Ref: R00900/WT/KG
Planning Portal Ref: PP-12661591

14th December 2023

NON-MATERIAL AMENDMENT (NMA) APPLICATION TO PLANNING PERMISSION REF. 23/3727/FUL:

400 EDGWARE ROAD, CRICKLEWOOD, BARNET, NW2 6ND

DRAWING No.
23032GA_21_115A

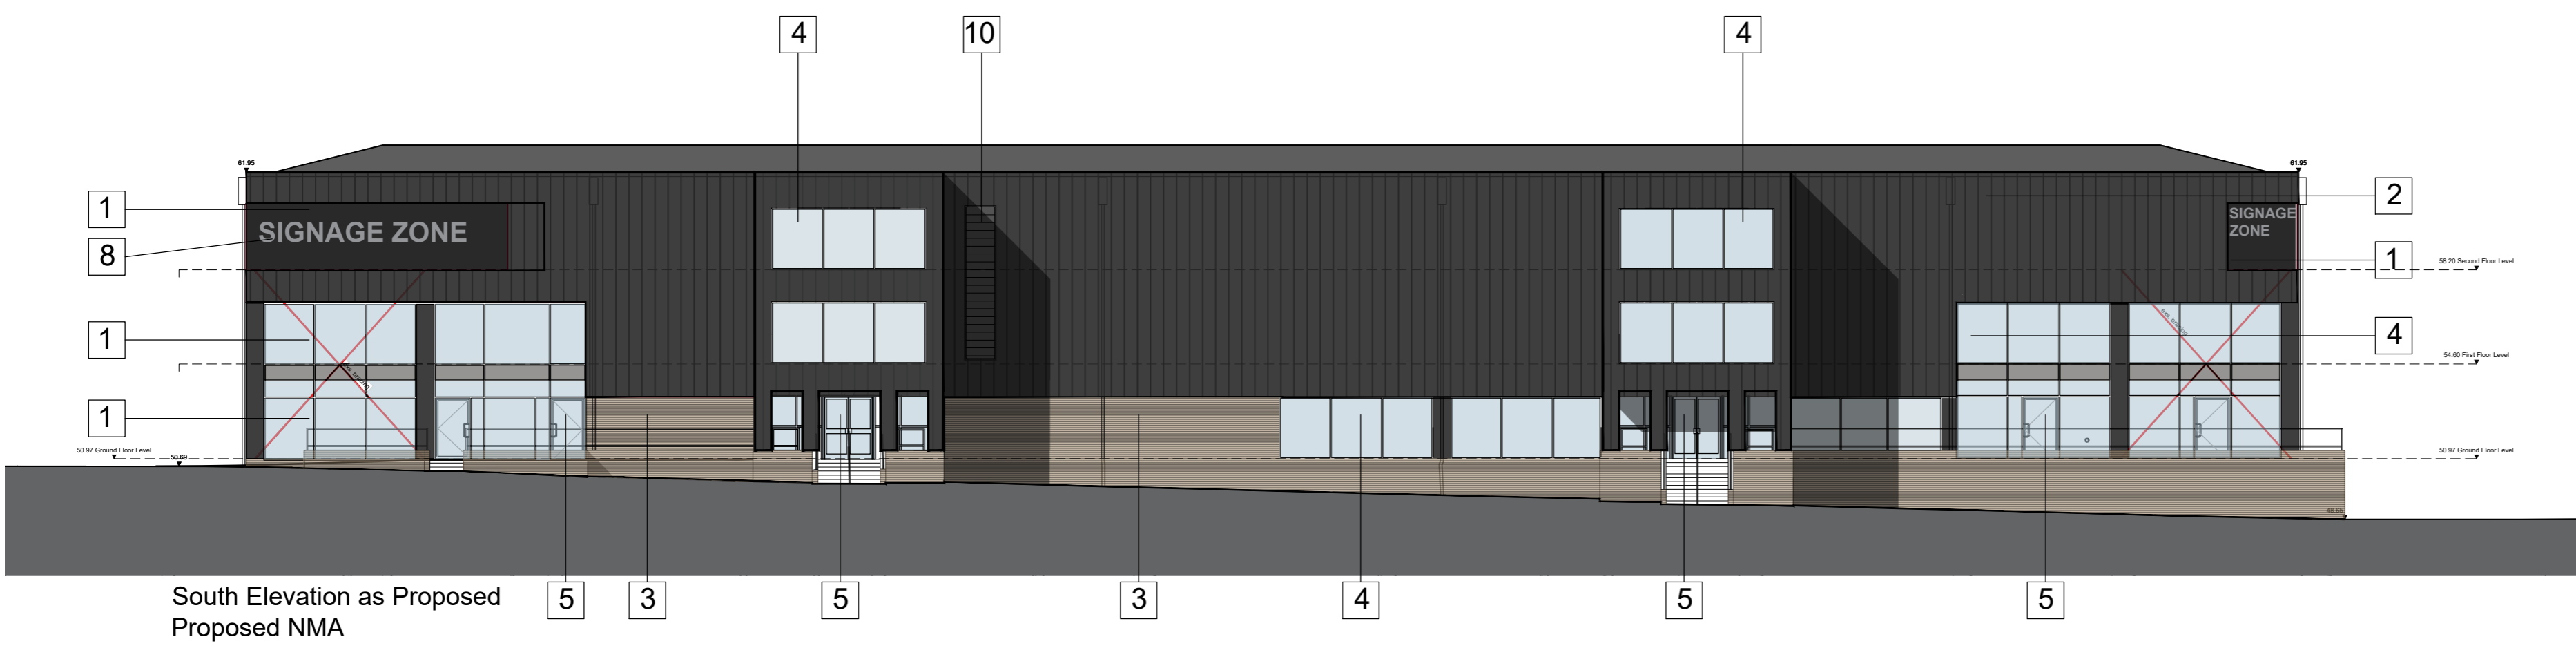
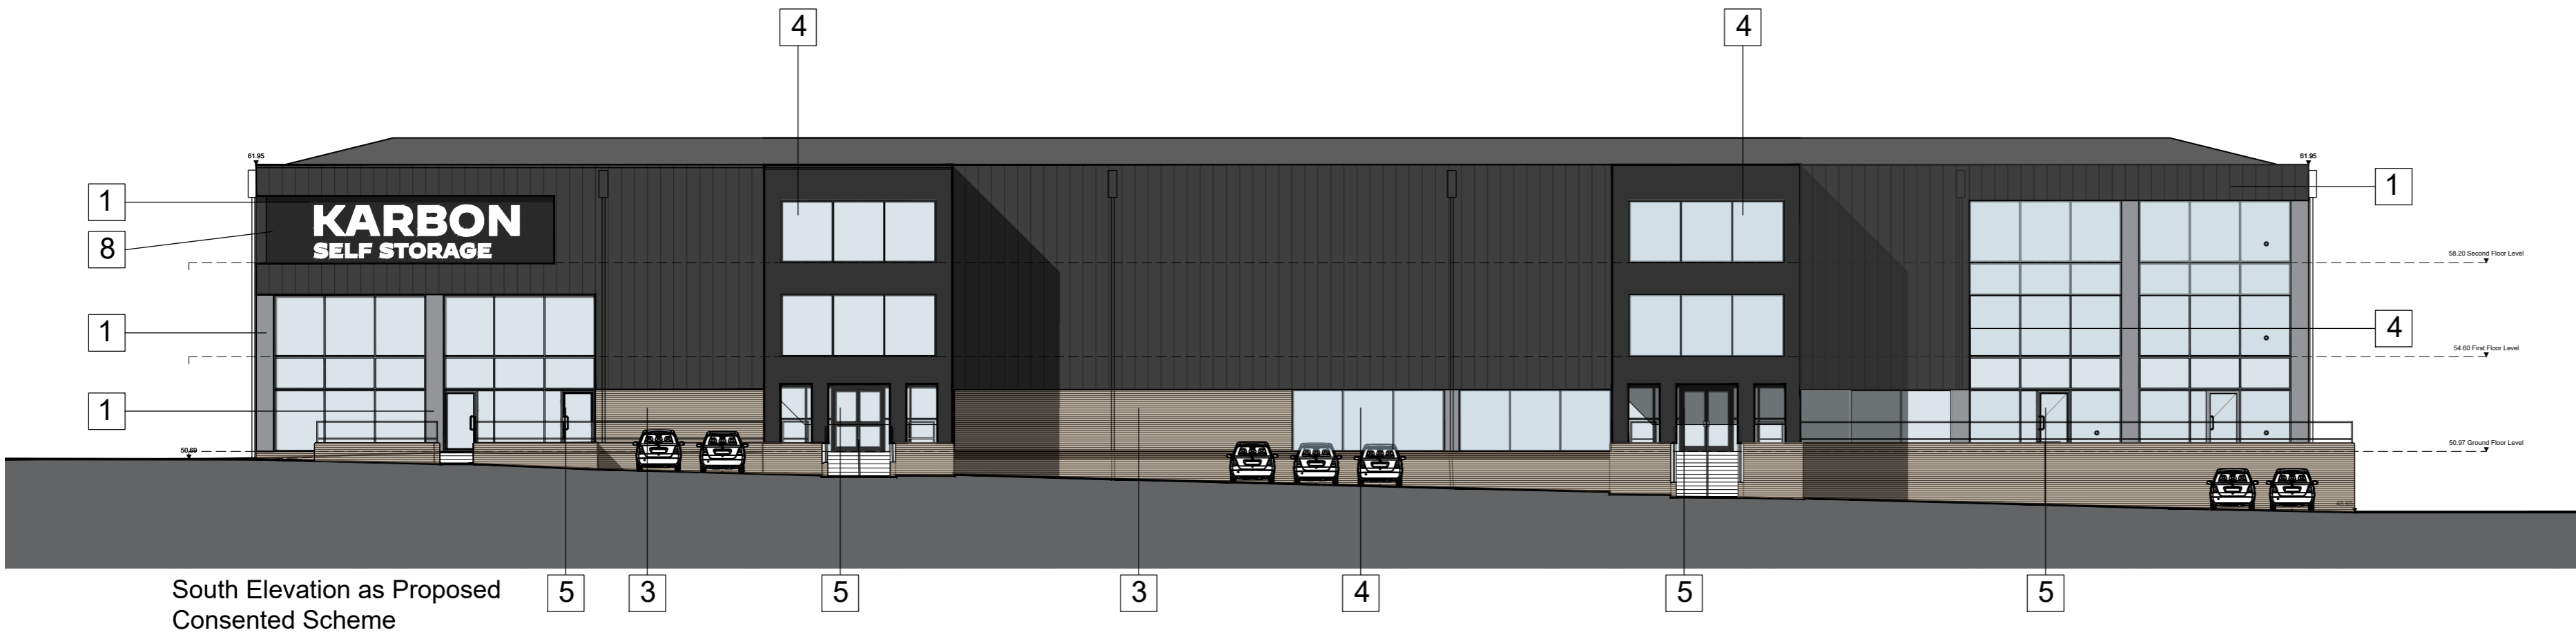
This application proposes an alteration to the upper section of the glazing on the eastern end of the

building's southern façade as approved, in order to balance the façade and increase the building's symmetry.

The proposed amendments are required in order to improve the overall design of the building. The proposed alteration of the glazing and the new signage above it will improve the balance and symmetry of the south façade, improving the appearance of the building as viewed from Edgware Road.

The revised South Elevation represents a minor alteration to the Proposed Elevations which were approved with permission ref. 23/3727/FUL. The proposed change is shown in the two Figures below:

The overall change to the appearance and character of the building is negligible and will have minimal material impact on the overall development. The purpose is to ensure a symmetry between the northernmost and southernmost glazing detail on the principal elevation facing Edgware Road. This will also assist in mitigating any impact of overheating of the building.

This Non-material Amendment looks to alter the wording of this condition to include the revised south elevation, for reasons detailed above. The list of approved plans should now include document '23032GA_21_115A' which accompanies this application.
